WEST SUSSEX COUNTY COUNCIL CONSULTATION

TO:	Arun District Council FAO: Raymond Cole
FROM:	Stephen Gee WSCC - Highways Authority
DATE:	12 October 2020
LOCATION:	Land at Ford Airfield Ford, West Sussex
SUBJECT:	F/4/20/OUT Outline planning application (with all matters reserved except for access) for the development of up to 1,500 dwellings (Use Class C3), 60-bed care home (Use Class C2), up to 9,000 sqm of employment floorspace (Use Classes B1), local centre of up to 2,350 sqm including up to 900 sqm retail / commercial (Use Classes A1-A5) and 1,450 sqm community / leisure floorspace (Use Classes D1-D2), land for a two-form entry primary school (Use Class D1), public open space, allotments, new sports pitches and associated facilities, drainage, parking and associated access, infrastructure, landscape, ancillary and site preparation works, including demolition of existing buildings and part removal of existing runway hardstanding. This application affects a Public Right of Way. This application is the subject of an Environmental Statement. This application falls within CIL Zone 1 - Zero Rated.

This response is the 2nd from the Local Highway Authority and responds to the additional

Figure 41: Access From Yapton Road - Proposed

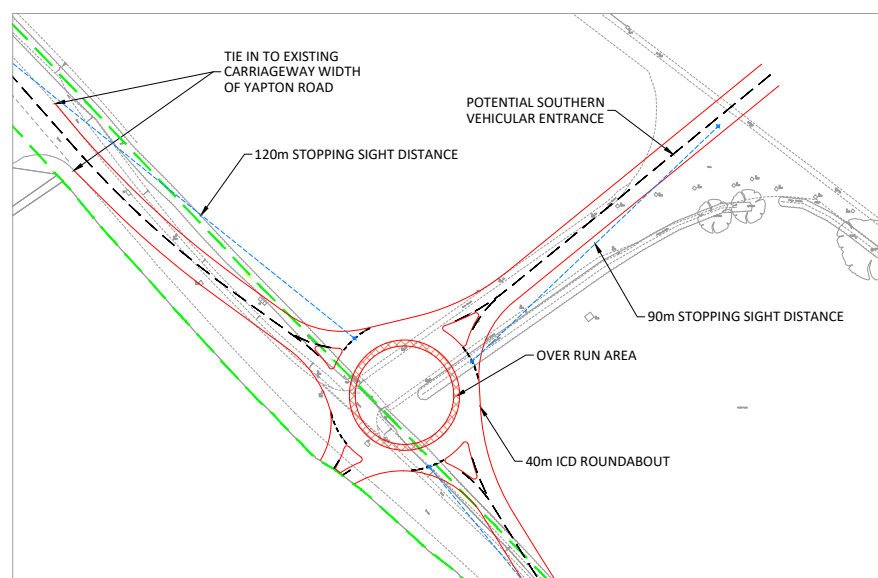
The applicant has provided additional information and confirmed that the whilst modelling has been undertaken on a 28m ICD roundabout it is a 40m ICD roundabout to be provided. The 4th arm serving an agricultural field has been considered as a simple crossover however following input from the landowner and a requirement to open/close a field gate clear of the highway this option has not been taken forward.
